CITY OF PORTLAND BUILDING PERMIT

PERMIT ID: 2013-00275

has permission to **Demo existing 12' x 22' garage, then relocate/rebuild 12' x 22' garage attached to the house by a 6'2" x 11'3" one story addition.**

Jonathan Rioux - Re: 70 olympia street garage

TYPICAL SECTION

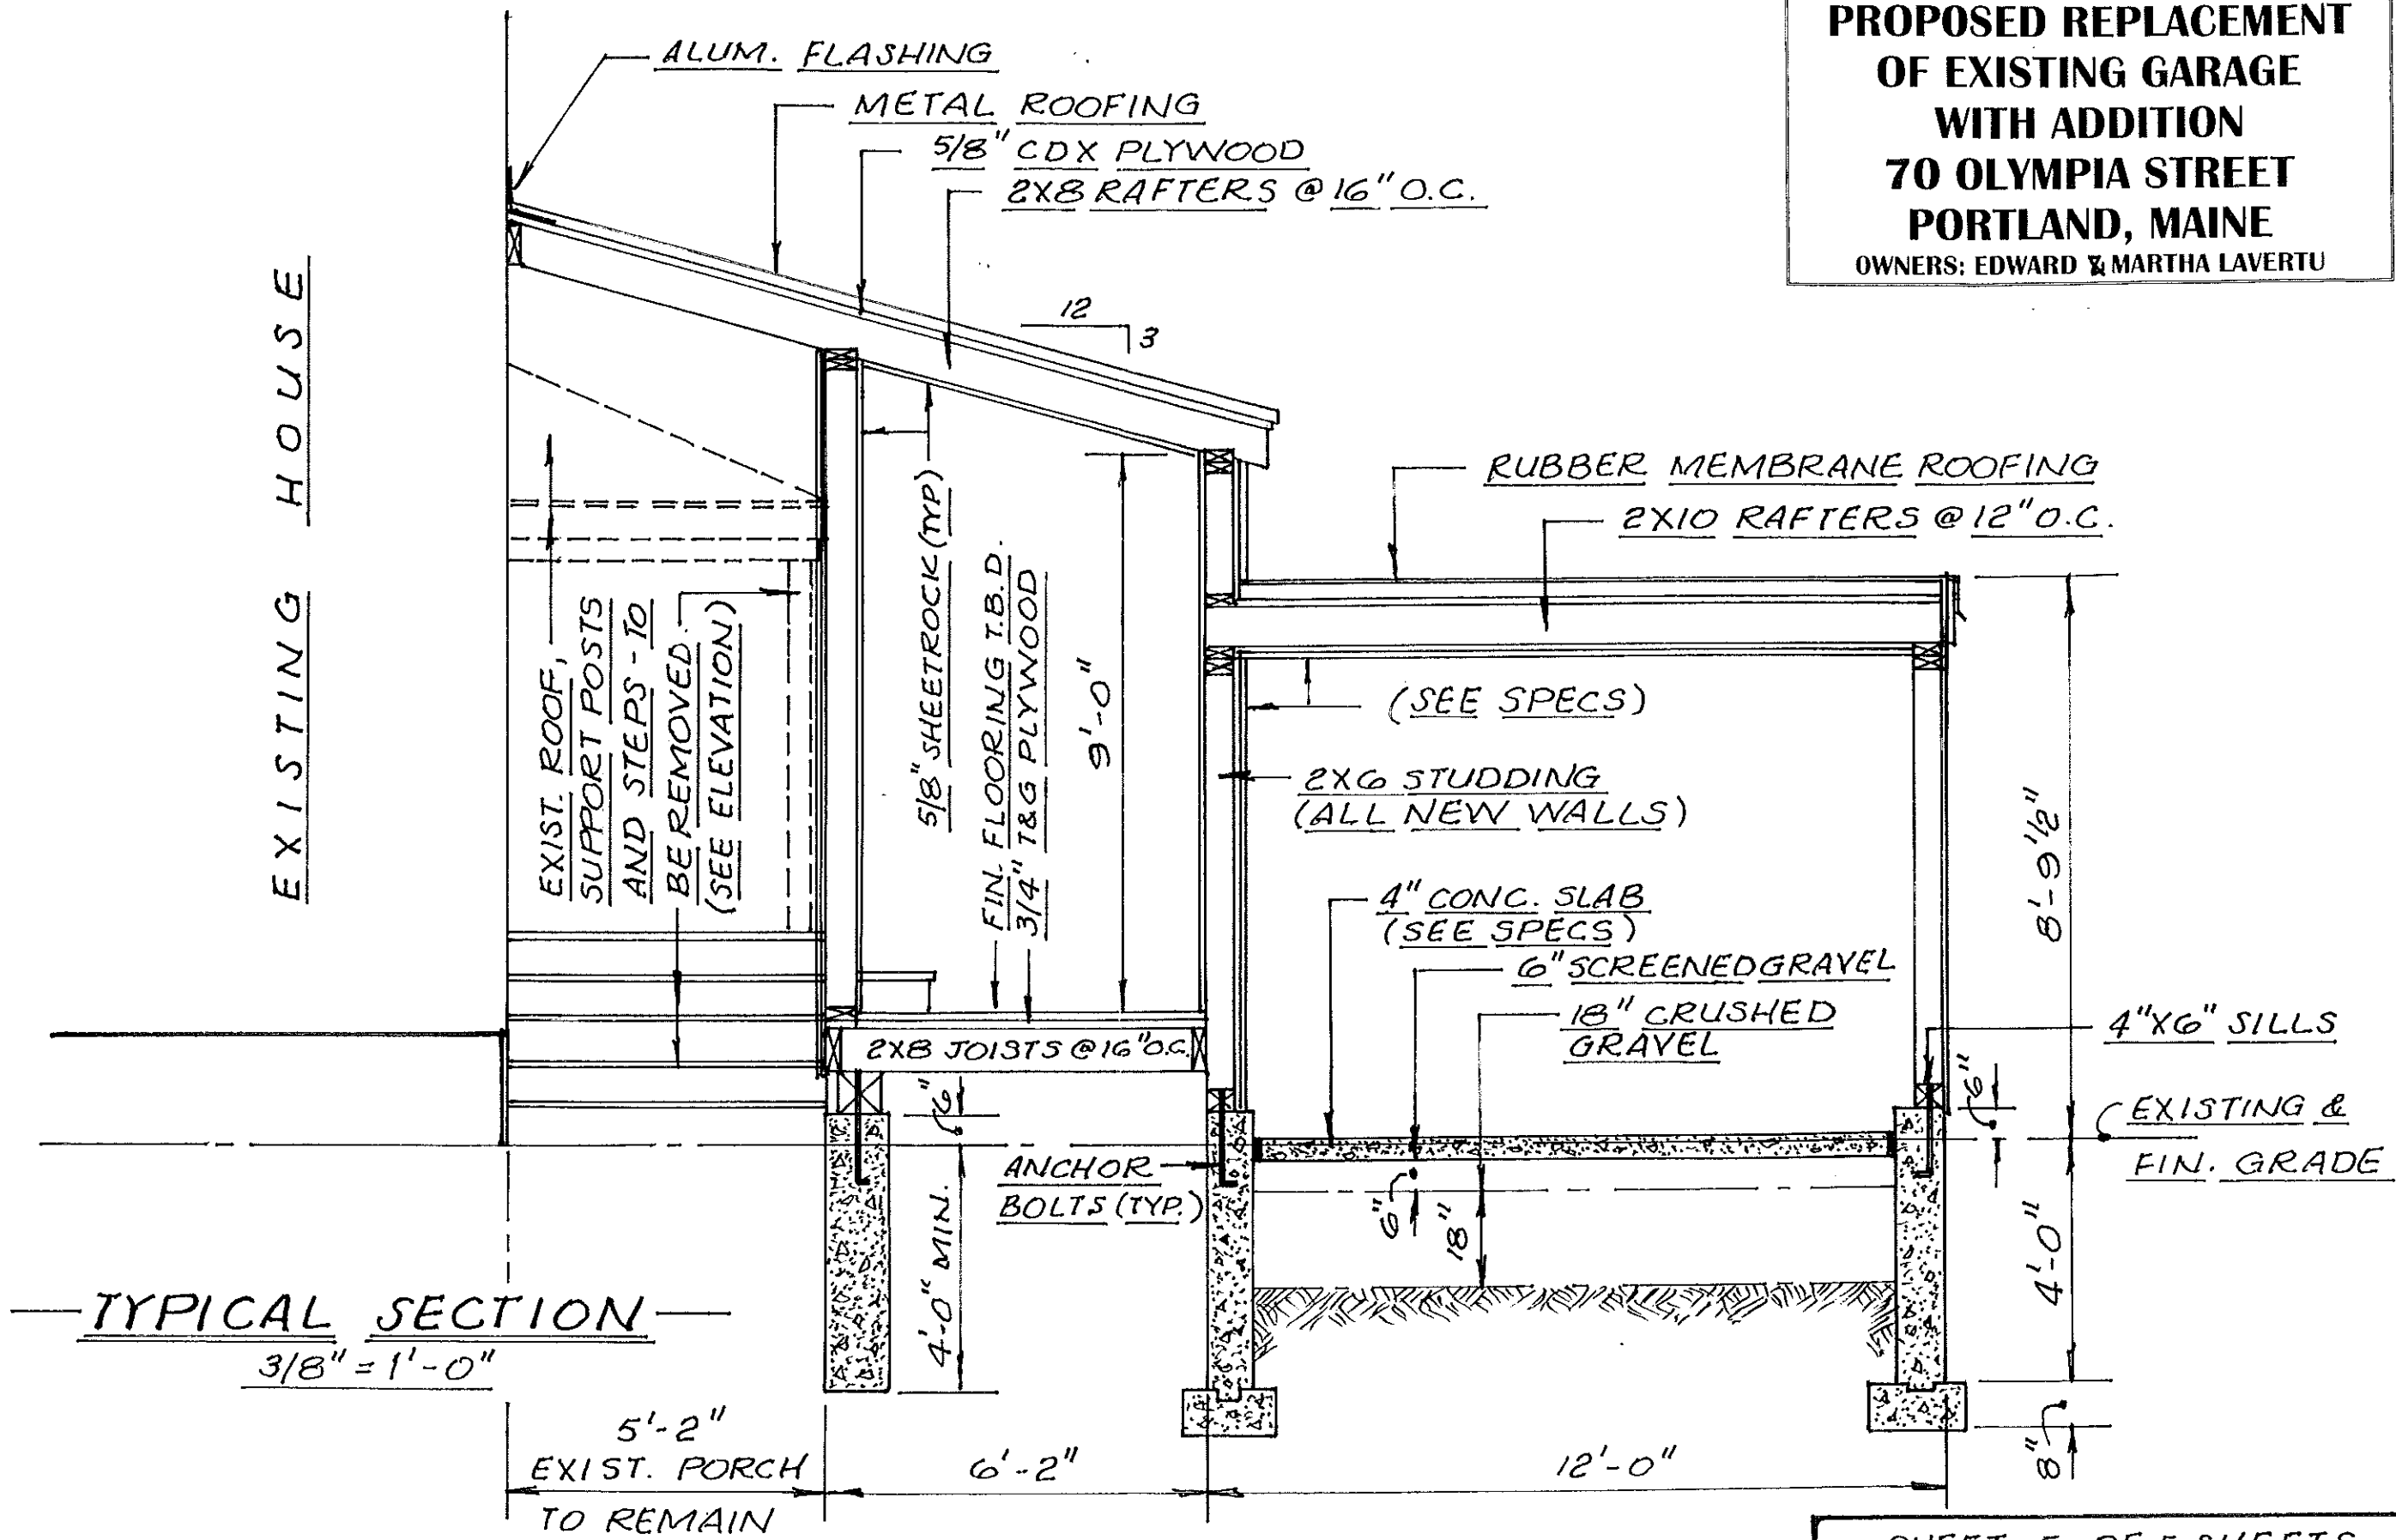
- Footing Dimensions/Depth (& wall thickness)(Table R403.1 & R403.1(1), (Section R403.1 & R403.1.4.1)
- Anchor Bolts/Straps, spacing (Section R403.1.6)
- Finish interior headroom(s)
- Interior/ exterior steps, door headers, & insulation
- All wall with less than 3:12 slope roof must be treated as a bearing wall.
- Framing & Connections (Section R802.3 & R802.3.1)
